April 2, 2024

Re: **Kendall Auto Group Auto Storage Yard - PA 23020**
IECO No. 20-1092

The project referenced above is revised in response to the review comments dated February 23, 2024. The review comments are numbered on the letter and have been addressed in *italics* as follows:

SITE ADDRESS: XXXXX SMOKEY POINT BLVD MARYSVILLE, WA 98223	
TAX ACCOUNT NO.'S: 31052800301200	
PA22-035	
SW 1/4, SEC. 28, T. 31 N., R.05 E., W.M. KENDALL AUTO GROUP	
DWG FILENAME: 201092-KENDALL4.DWG	DESIGNED BY: DNK
DATE: 03/12/2024	SCALE: 1"=30'
JOB NO.: 20-1092	SHEET: C1.1
EXISTING FEATURES MAP

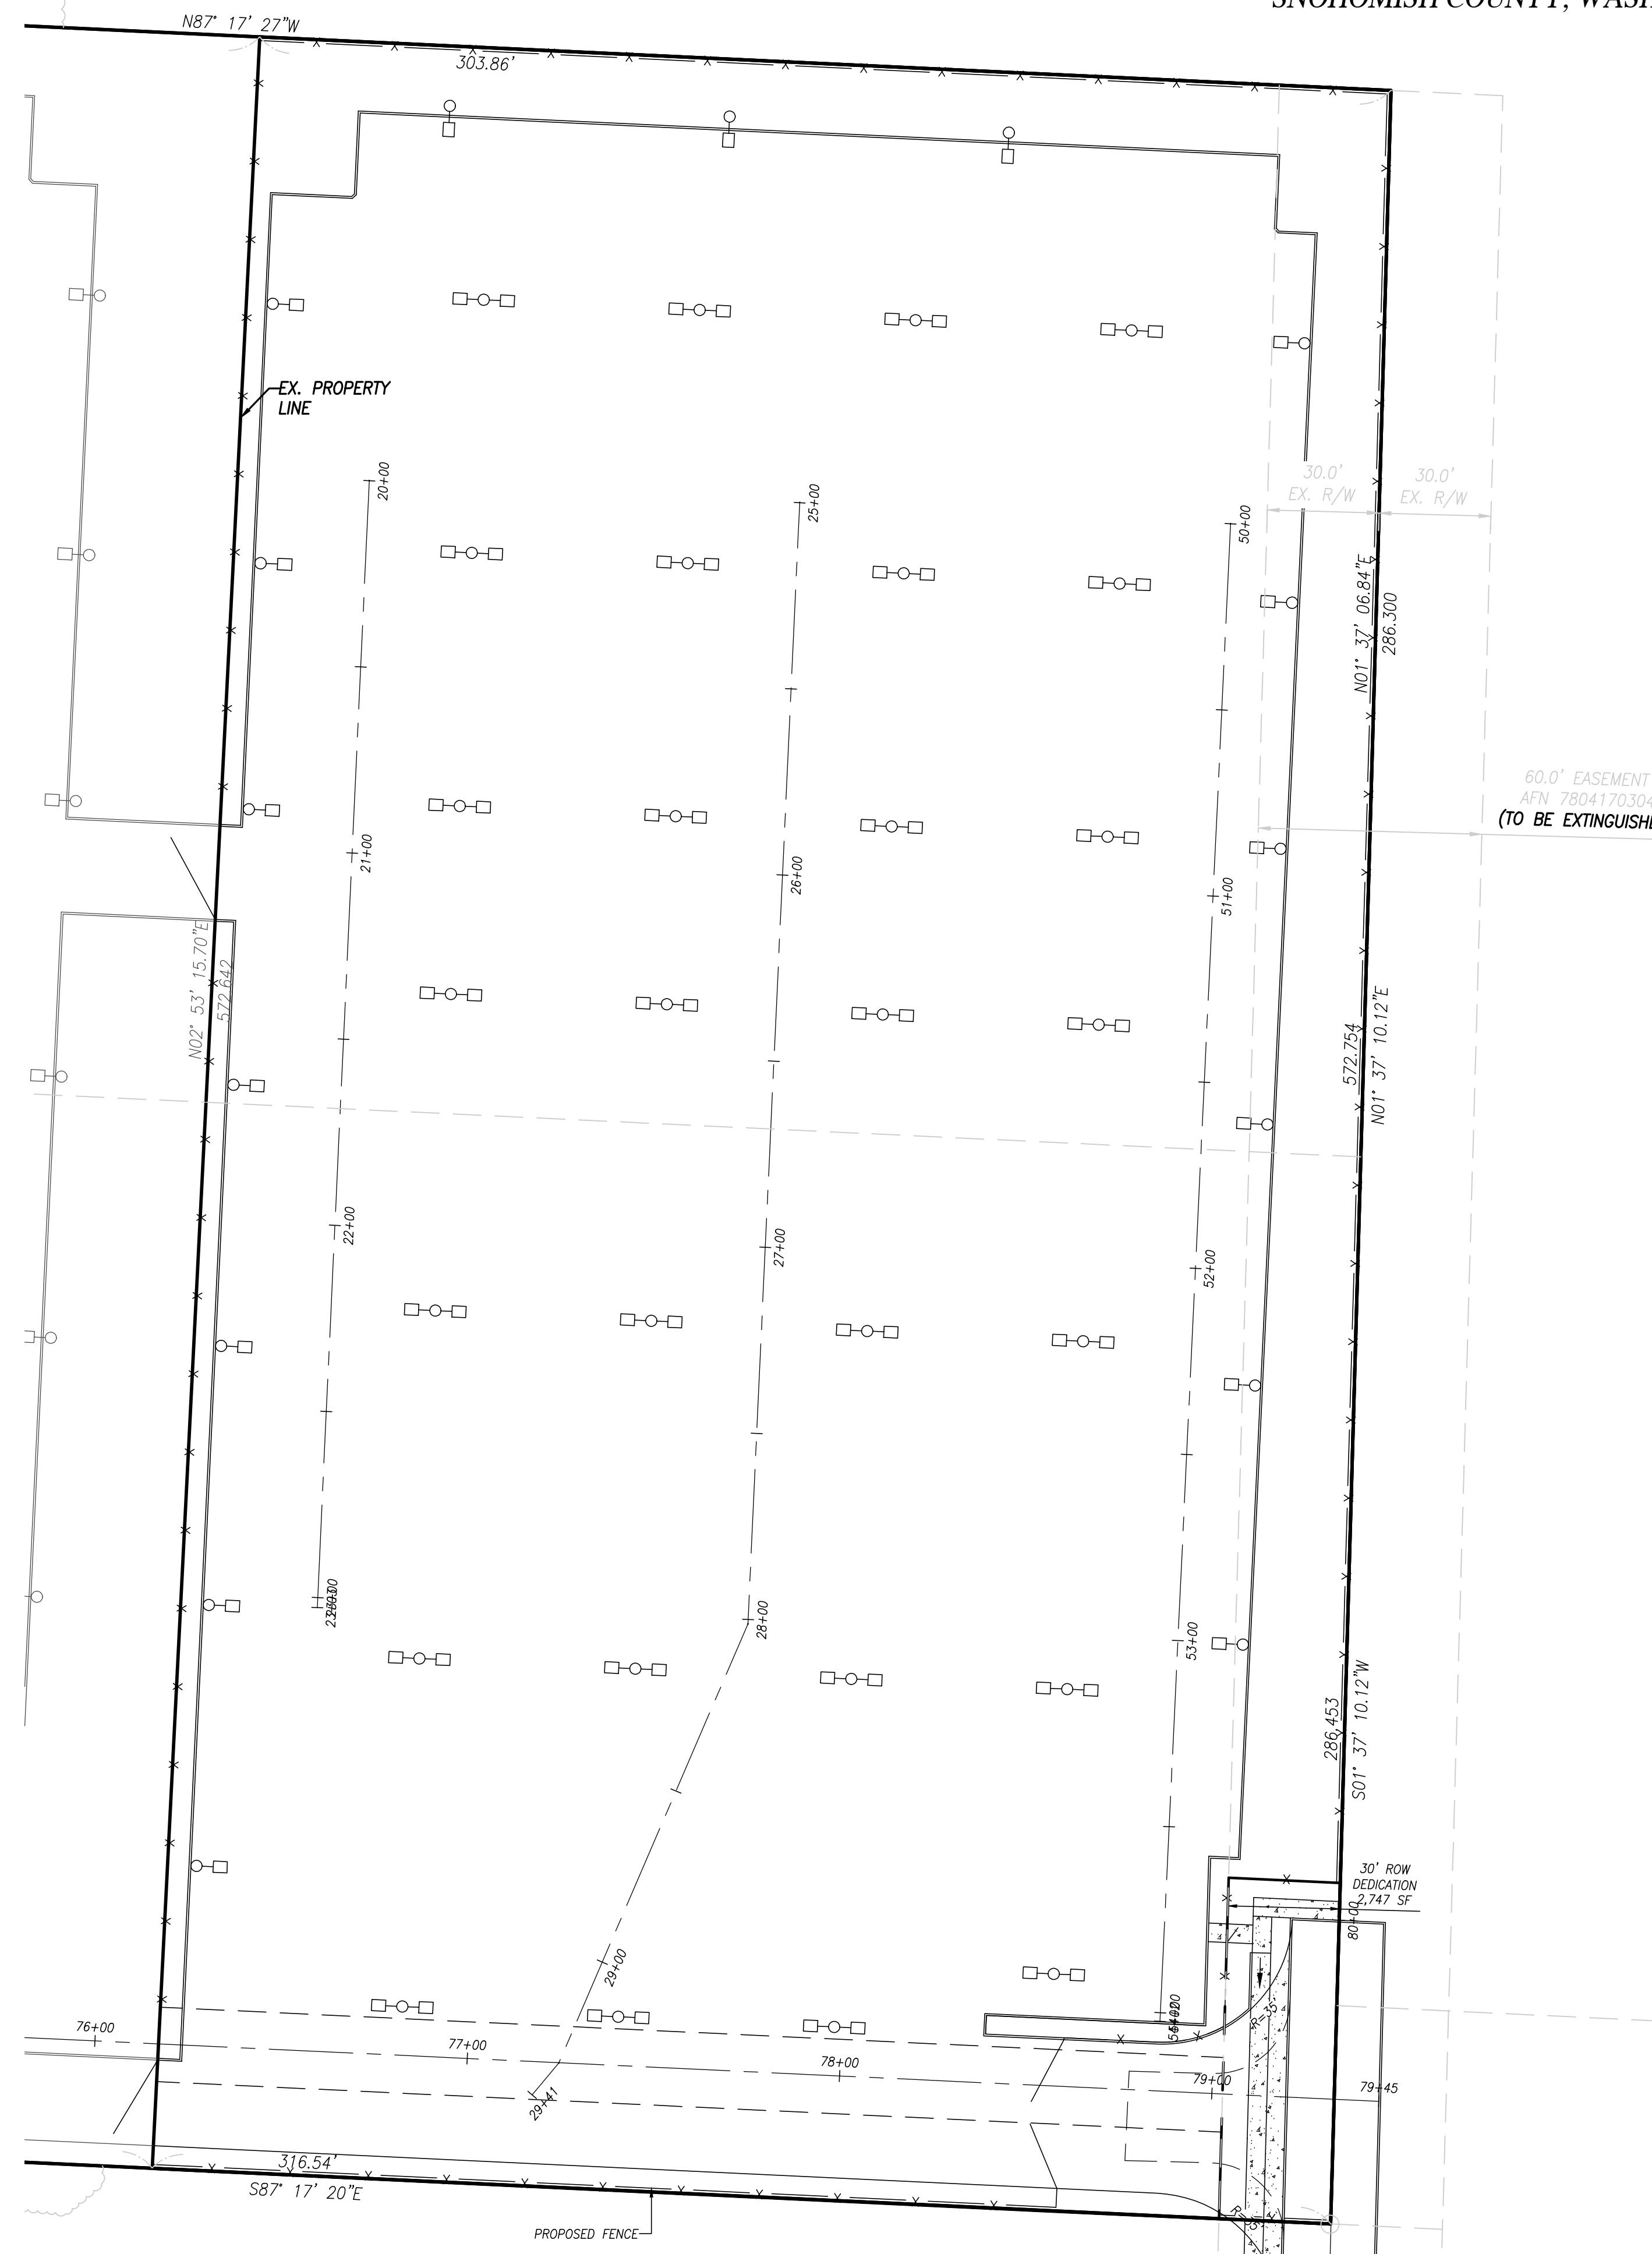
1. TR1 Comment: Amend sheets S1 and C1.1 to depict all encumbrances outlined in Schedule B of the Title Report prepared by Chicago Title Insurance Company, dated July 25, 2023. If the encumbrances cannot be depicted then they will need to be referenced.
TR1 Response: Encumbrances have been depicted onsite. Those that have not been depicted a merely referenced.
TR2 Response: In review of the title report there are number of easements that have not been depicted, and have not been referenced on Sheets S1 and C1.1 (i.e. AFN 201706210438, 201907310731 & 202306150110).

Please see the revised title report. The title report has been updated to not reflect the other tax parcels prior to the BLA. The only encumbrance on the property is the existing access easement on the east side of the property.
